# KITTITAS COUNTY

## DEPARTMENT OF PUBLIC WORKS

### MEMORANDUM

TO: Community Development Services  
FROM: Taylor Gustafson, Environmental/Transportation Planner TG  
DATE: February 28, 2019  
SUBJECT: Evergreen Ridge PUD Rockberry Loop LPF-19-00001

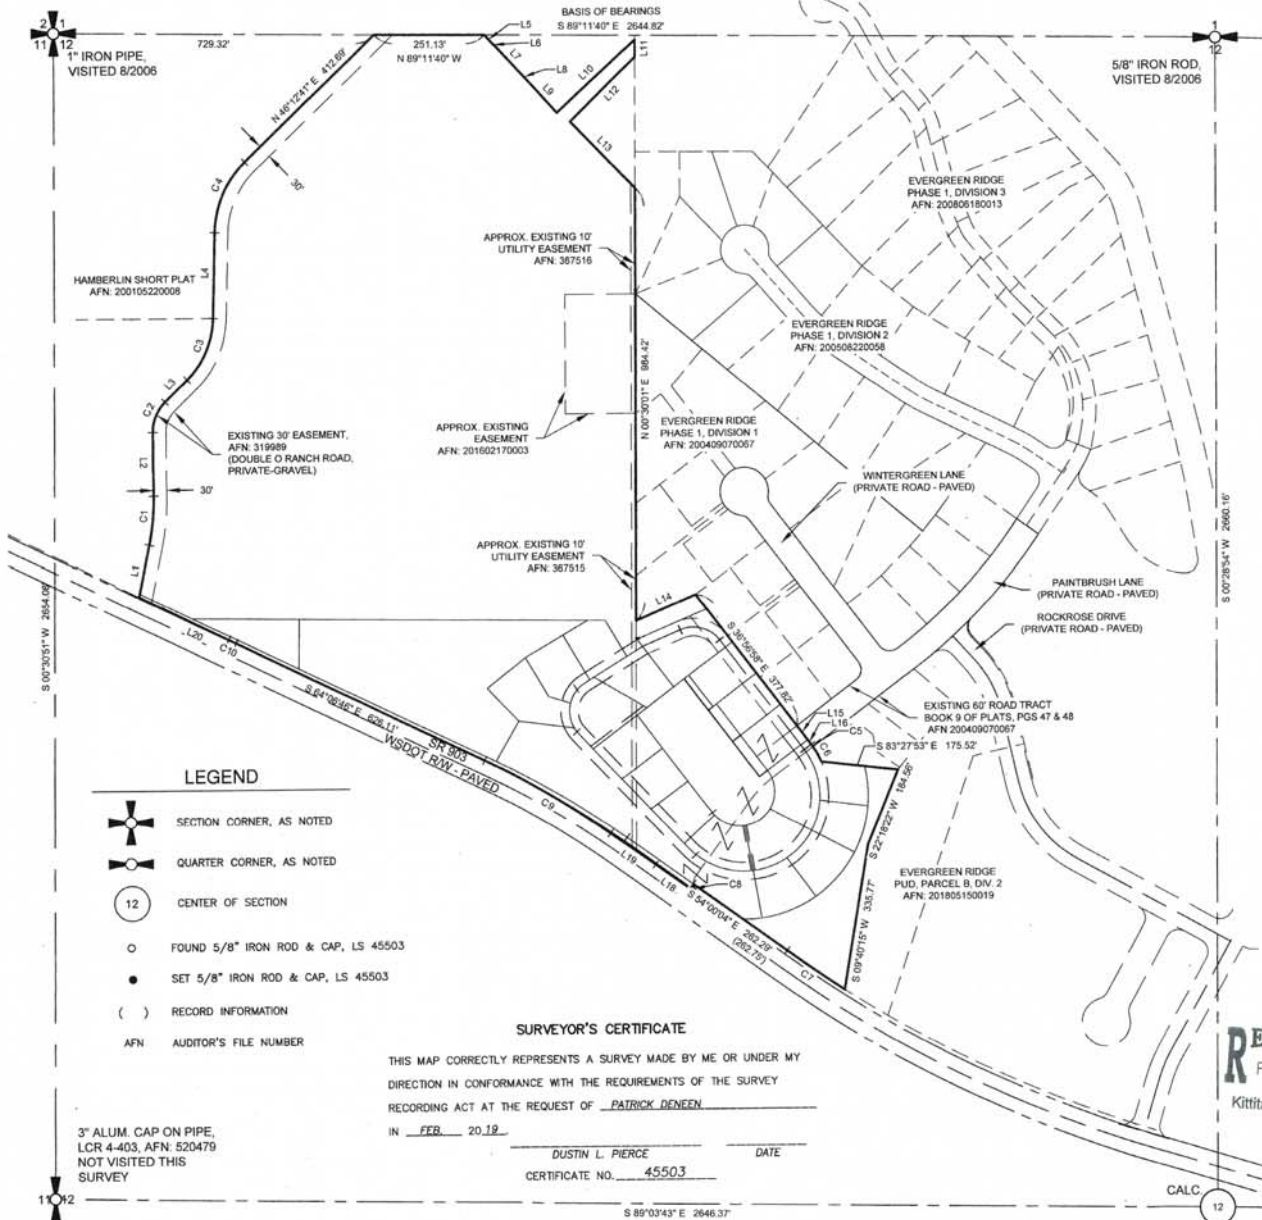
1. The direction of lines L6 and L8 are unclear. A detail window would correct.

KITTITAS COUNTY WASHINGTON		
DWN BY D.L.P./G.W.	DATE 02/2019	JOB NO. 16078
CHKD BY D.L.P.	SCALE 1" = 100'	SHEET 2 OF 6

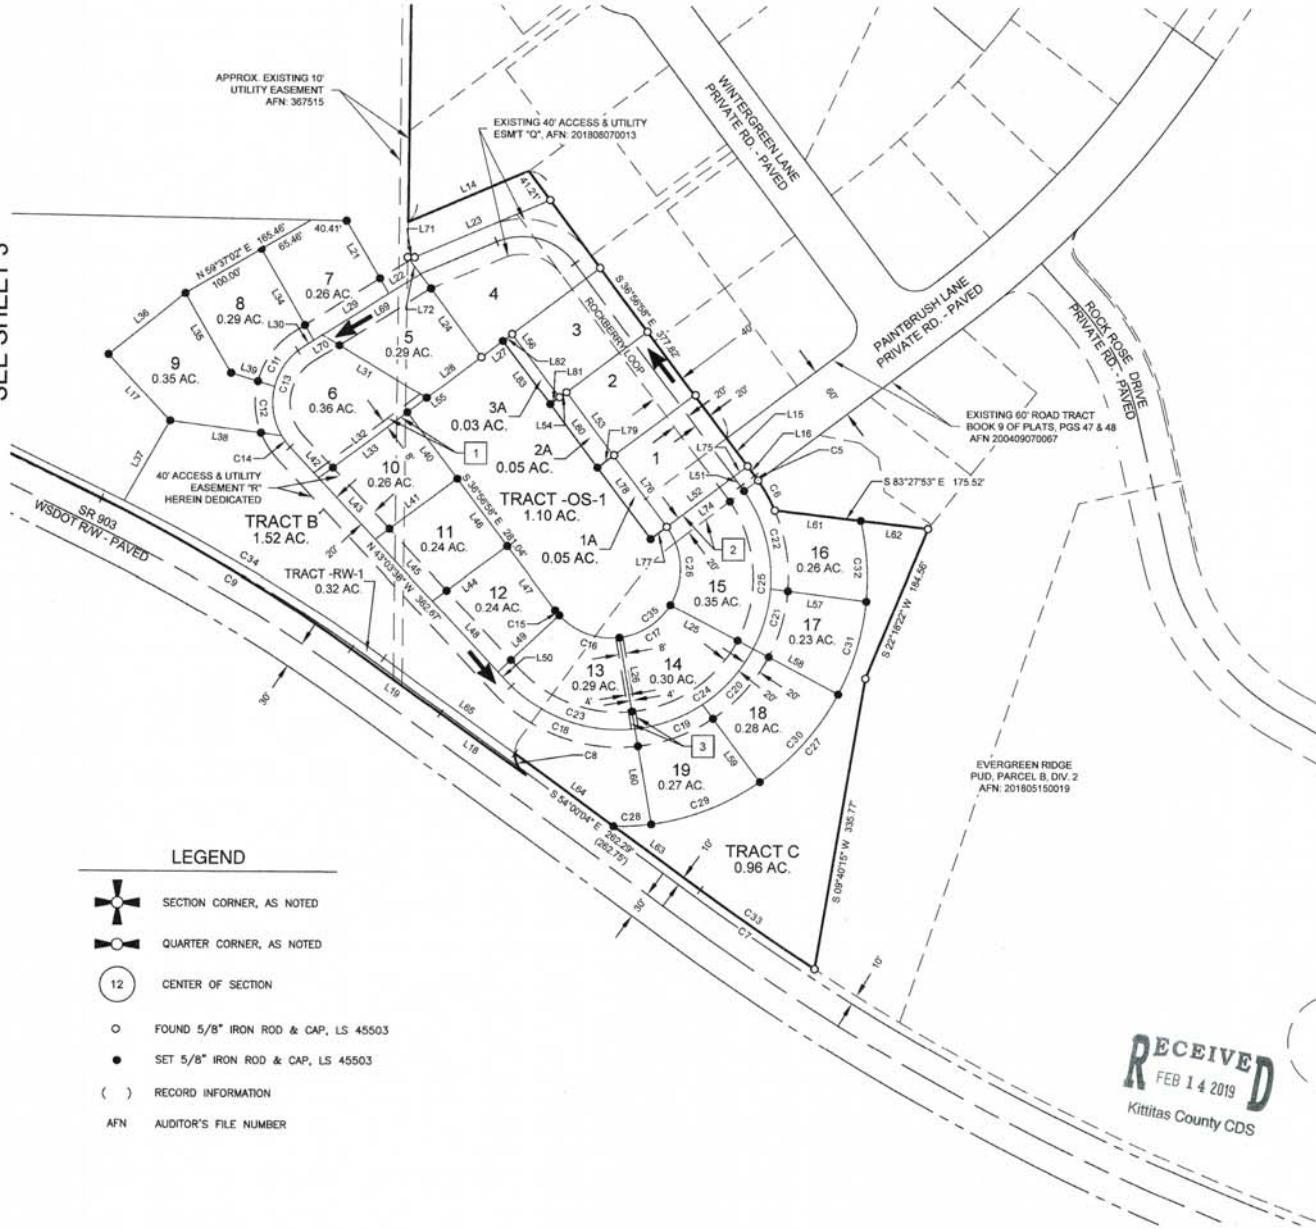
2. The North line of Lot 7 does not show a bearing. Showing the total length (940.41) of the line would also assist in relating Sheet 2 to Sheet 3.
3. Lots 1-4 should show the record document used to create them.
4. The NW line of Lot 10 (L33) does not match closure report. (Report shows S53°03'22"W)
5. The NWmost line of Lot 16 (L75) does not match closure report (Report shows 20.00')

6. The Southernmost Arc on Tract RW-1 is a Non-tangent Arc. Please include a radii or tie to center of arc to make it retraceable.

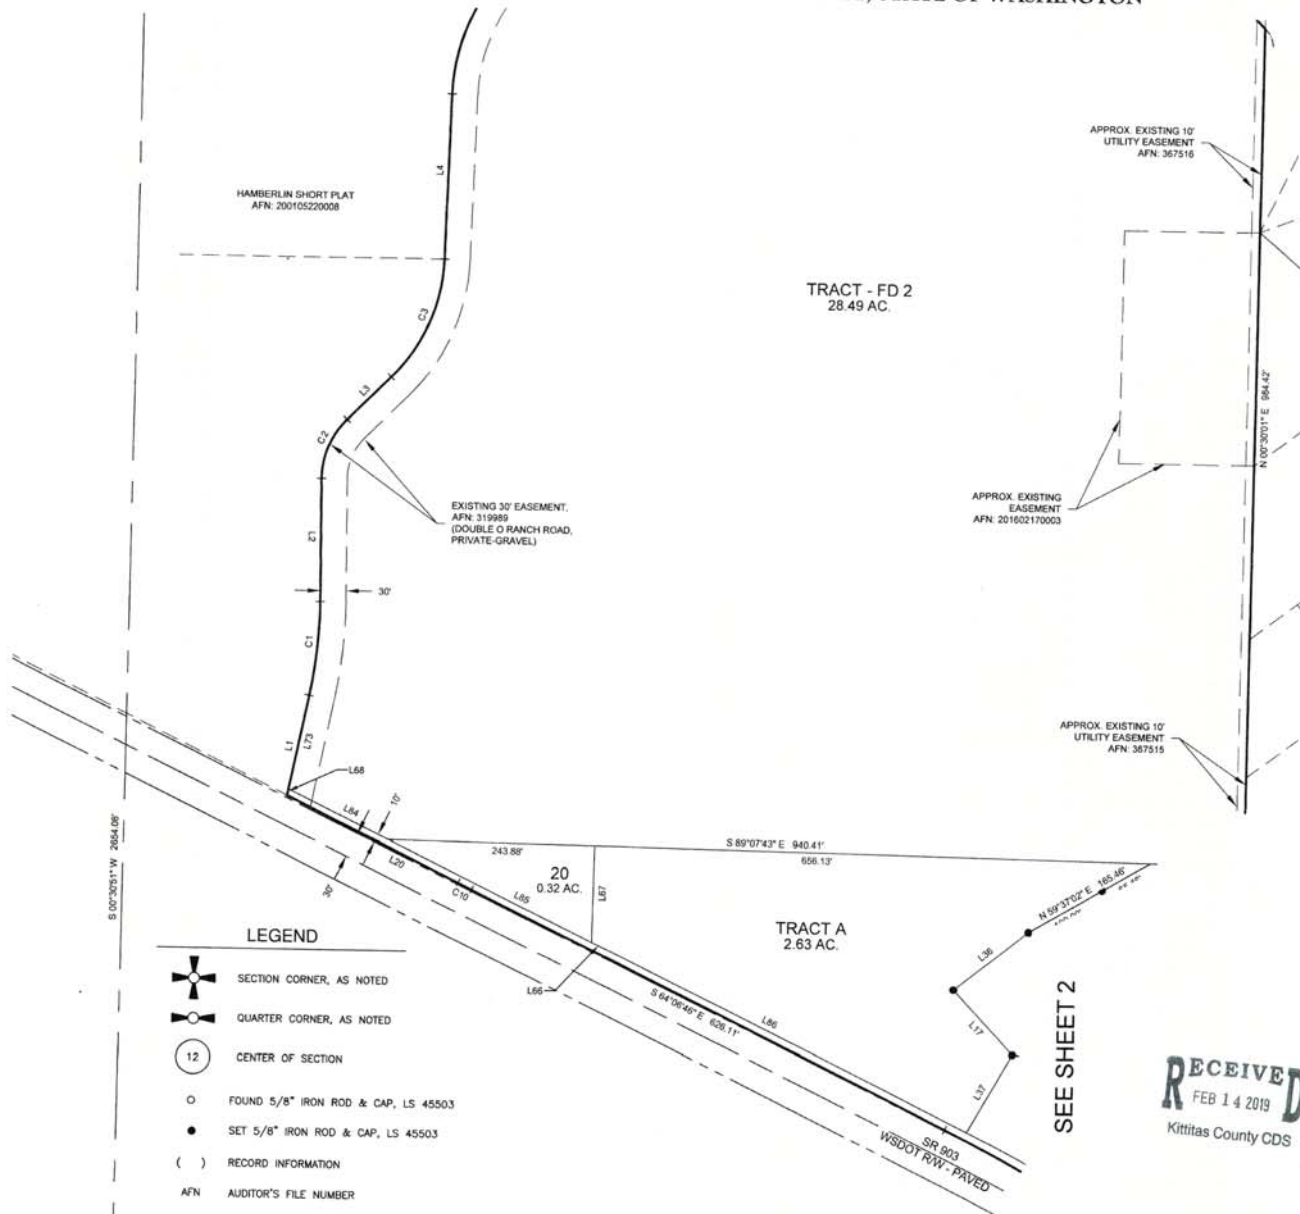
7. The dimensions near the Easternmost corner of Tract A have been cut off. Please fully include or exclude these dimensions.
8. Identify Tract RW-1 on sheet 3.
